From: Amy Myer <Amy.Myer@arun.gov.uk>
Sent: 10 August 2020 11:01
To: Planning.Responses <Planning.Responses@arun.gov.uk>
Subject: FW: R/102/20/PL - Cross Rd - CONSERVATION COMMENTS

R/102/20/PL

The current application is for a revised building to the rear of The Spires, which is a property of note which I believe was designed by Reginald Fairfax Wells. It can be identified as a non-designated heritage asset due to the architect in accordance with the Planning Practice Guidance.

Drawing
Proposed elevations
Front and Rear

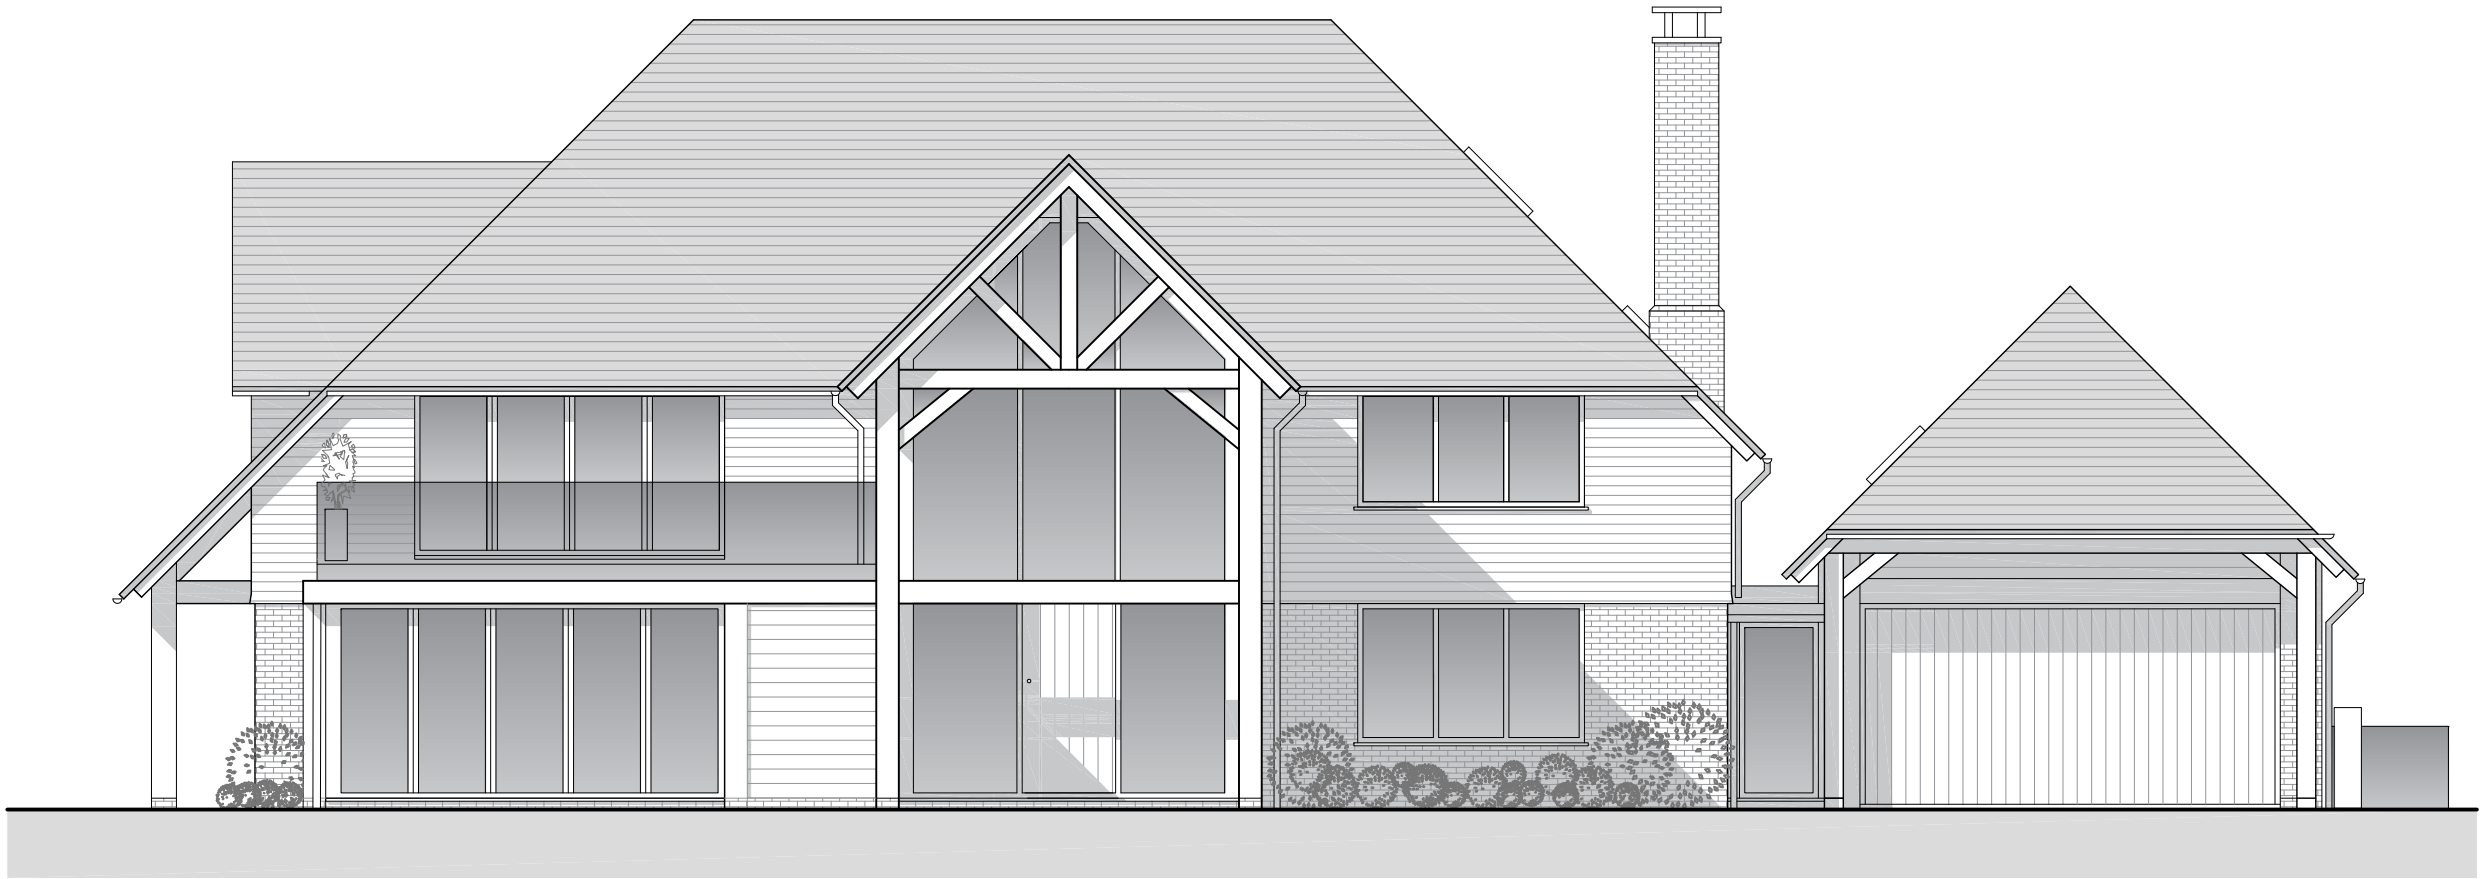
The proposed new house is more modern in appearance, whereas the previous design was very much Edwardian with tile hanging and rendered elevation with brick detailing. However, I do not think that the revised design will cause unnecessary impact to the setting of the non-designated heritage asset. This is subject to the use of suitable materials, which you may wish to condition
